From: Nat Slade
Sent: 15 May 2014 17:05
To: Planning.Responses
Subject: FW: Planning Consultation on: BN/22/14/PL

APPLICATION **BN/22/14/PL**

Site Address: The Cottage Piggeries Church Lane Barnham PO22 0DB

Description of Works: Application for the variation of condition 3 following planning approval BN/22/11 for the siting of 1No. 3 bedroom mobile home.

/// = Existing Driveway & Hard Standing
 The Cottage Piggeries
 Barnham
 PO22 0DB

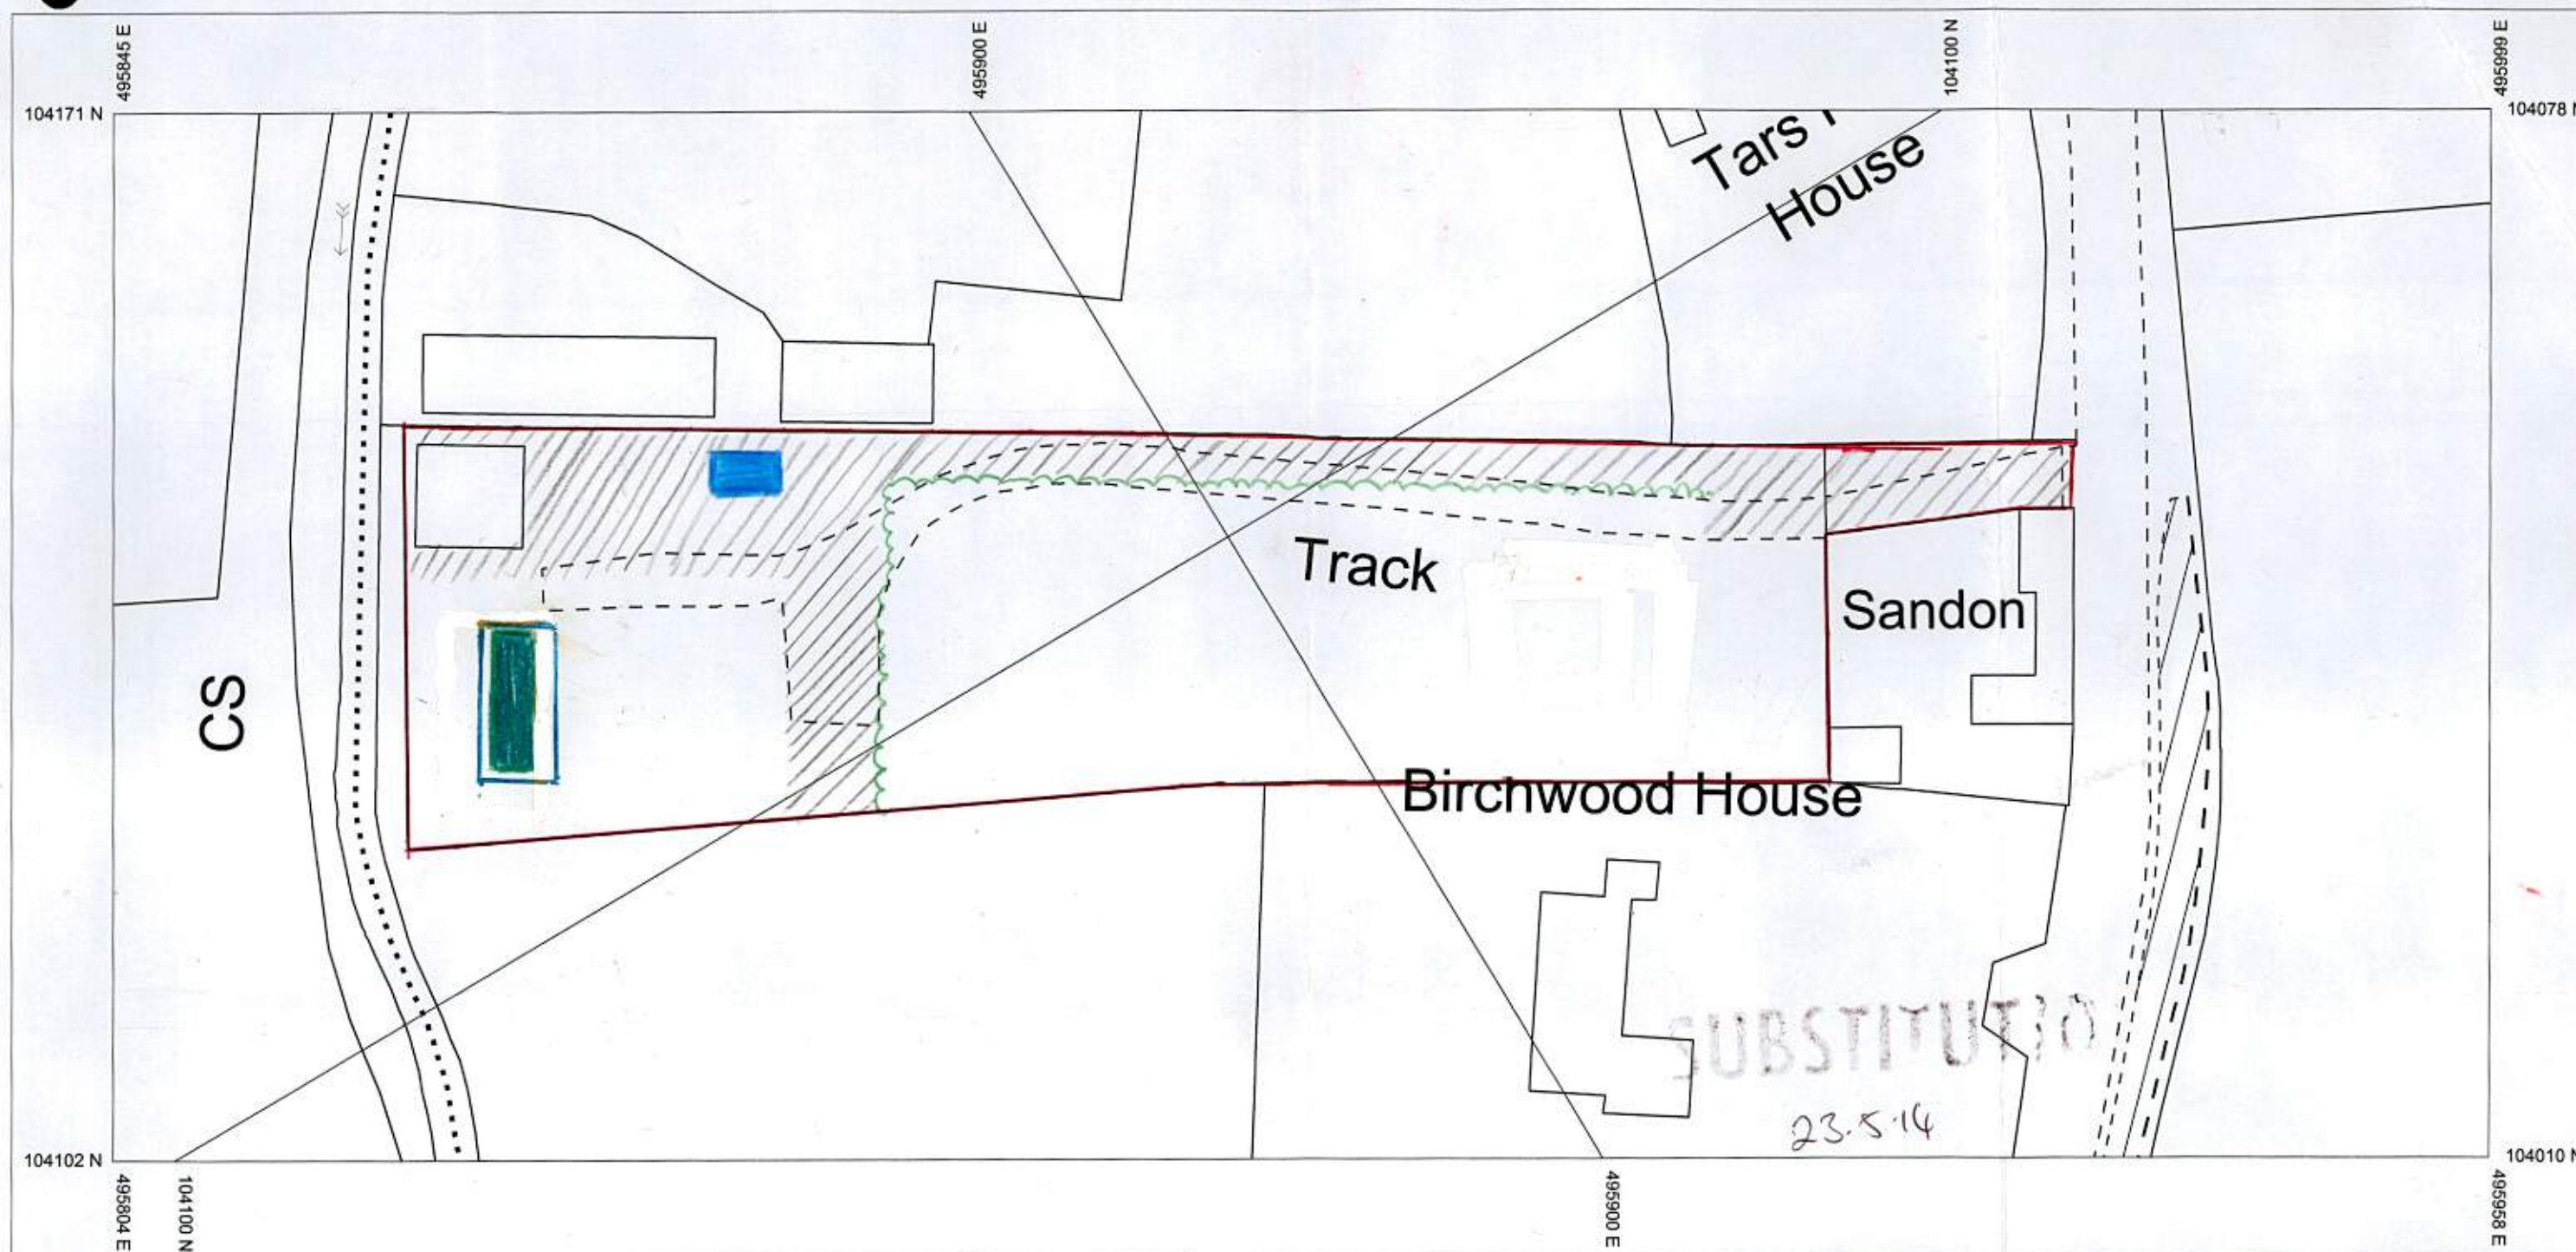
The application is for a caravan of up to 22 feet in width. The maximum width of a caravan defined in the Caravan Sites Act 1968 is 20 feet.

It is unclear to me from the plan submitted if the location of the proposed caravan meets the necessary 3 meter minimum gap between the caravan and the site boundary.

1. No caravan or combustible structure shall be positioned within 3 metres of the boundary of the site.
2. The caravan shall be connected to a road by a footpath with a hard surface which shall be maintained in good condition.

7. The caravan must not exceed 20 feet in width, 60 feet in length and must not exceed 10 feet in height from the floor to the top of the structure.
